From: Richard Temple
Sent: 26 November 2015 09:11
To: Planning.Responses
Subject: FW: Historic England advice on Application no(s) BN/29/15/PL

Land at Barnhan Court Barnham
Application No(s):BN/29/15/PL

FIGURE 14
Typical fence details

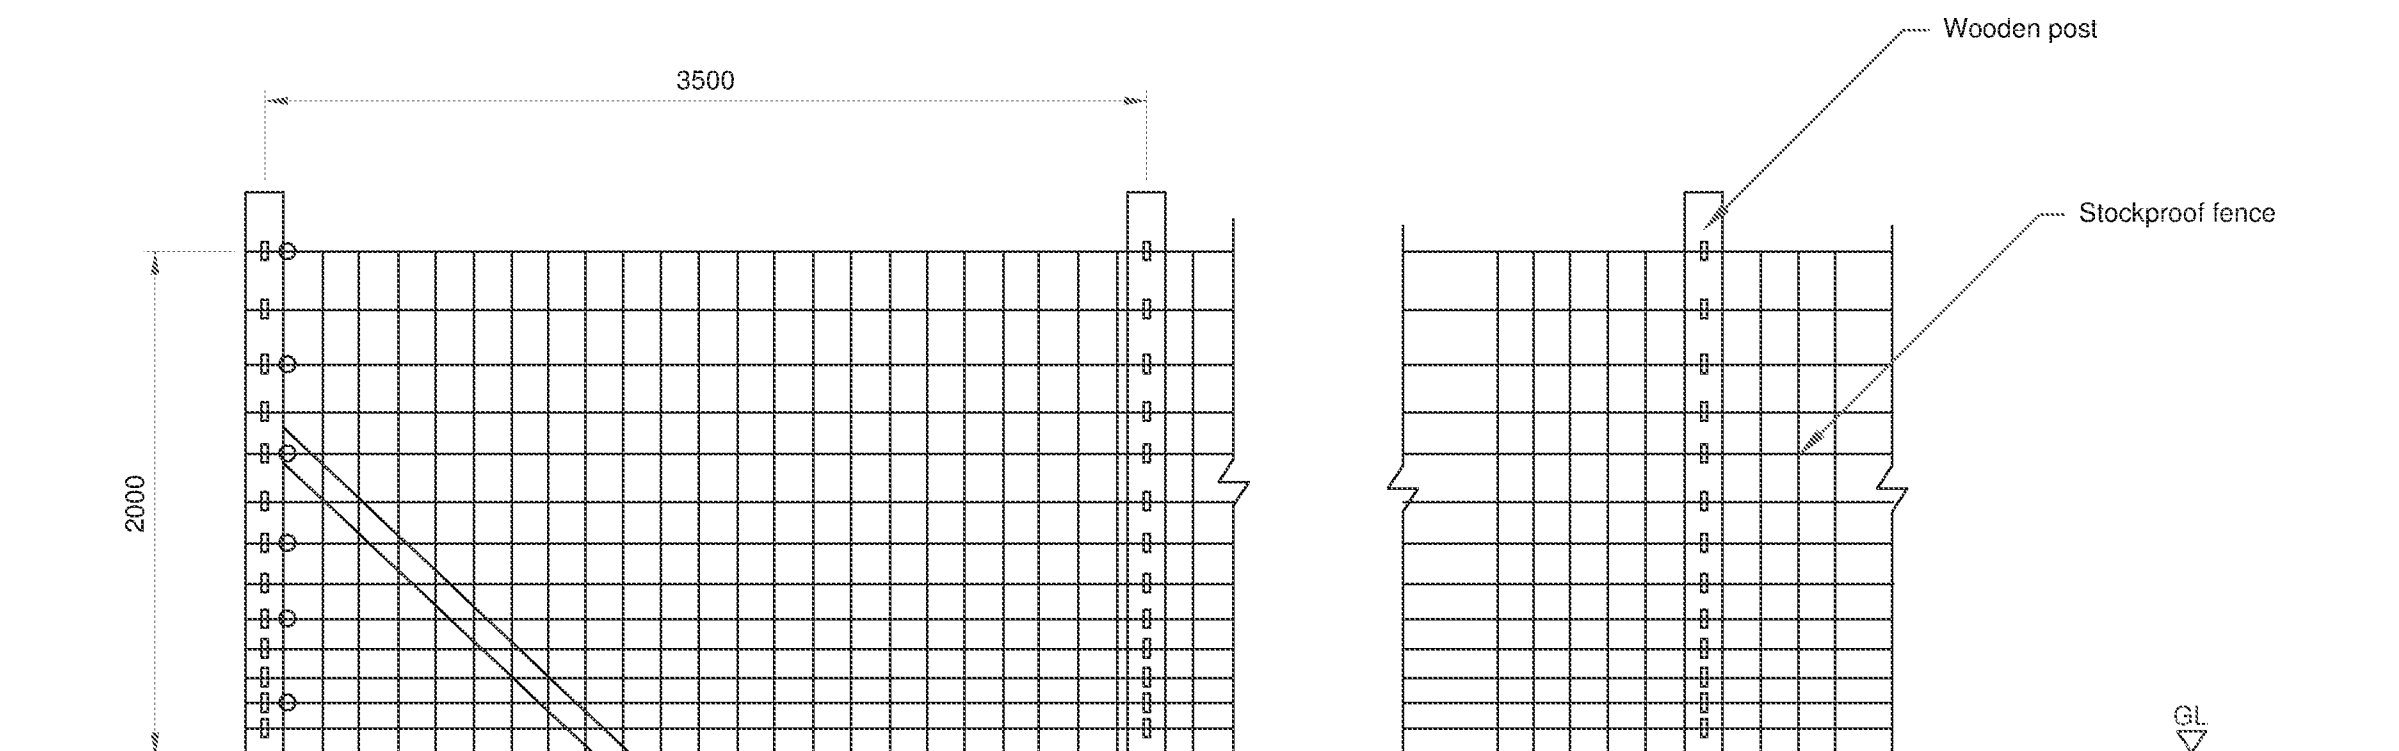
All that said, there is some mitigation (in theory) that should be taken into consideration in as much that the site is considered temporary and as such reversible. There could also be further measures put in place regarding boundary treatments, particularly as the site is going to take on a more industrial character with

fencing to enclose it. This would need to be carefully considered so as not to harm the landscape character and could potentially be a condition should the application be supported.
